# Development Application and Planning Proposal Review NSW Planning Portal Concurrence and Referral

Authority	Authority's Reference	Agency Concurrence and Referral	Authority Contact	Authority Notification	Submission Due	Submission Made
NSW Dept. of Planning, Housing & Infrastructure	SSD-64916225		Ingrid Zhu	29/08/2024	26/09/2024	30/08/2024

Address	Land Title
171 Victoria Road, Parramatta	Lot 100 DP 816829

Environmental Impact Statement (EIS) for the Western Sydney University (WSU) Indigenous Centre of Excellence. Construction of a new building (floor area approximately 6,000sqm) at the WSU Parramatta South Campus, on the site of the existing P1 carpark. The building would comprise arts, education and community spaces designed and led by Indigenous peoples.

DRAWING NUMBER
DA 0-102

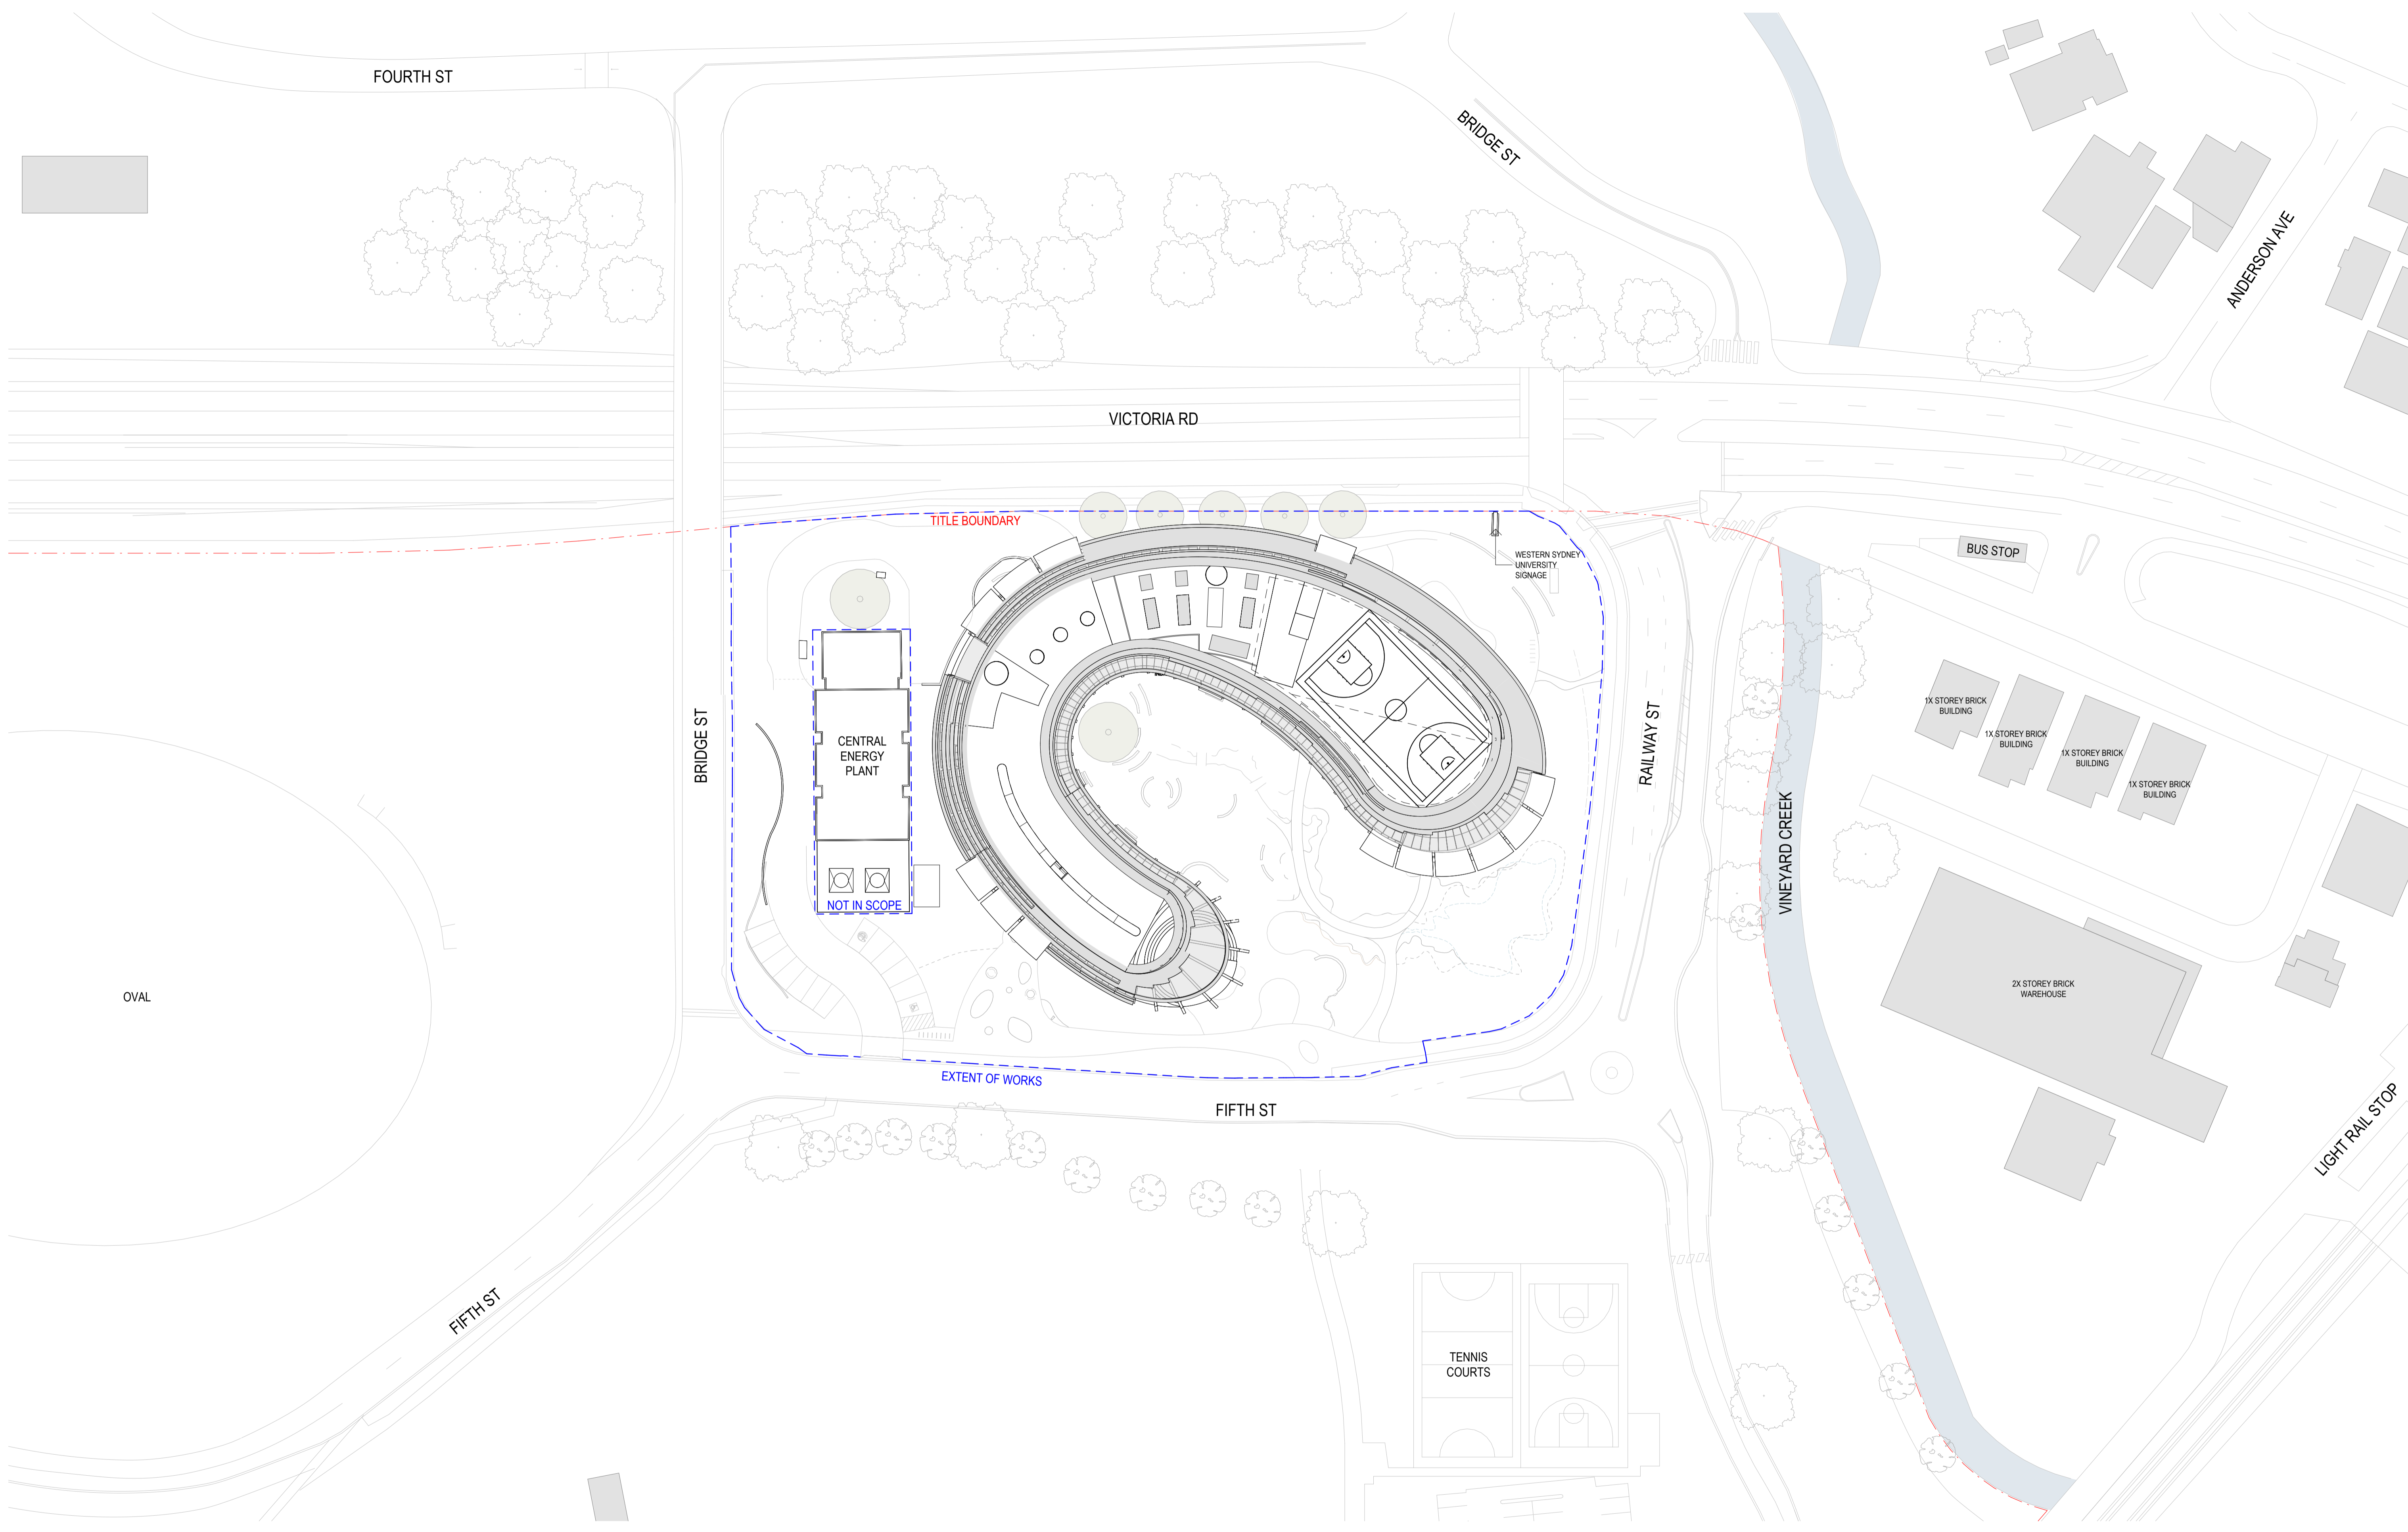
The Architectural Drawings do not appear to show provision for the 'new pad mount substation'.

The EIS indicates 'Boundary Setbacks Northern: 2.83m' being to the Victoria Road frontage where there are low voltage overhead power lines.

The Architectural Drawings show 'Western Sydney University Signage' immediately adjacent to the front property boundary. The EIS indicates 'It is noted the existing Campus signage pylon sited at the intersection of Victoria Road and Railway Street at the north-east of the development footprint area will be retained' but does not appear to further address the additional signage.
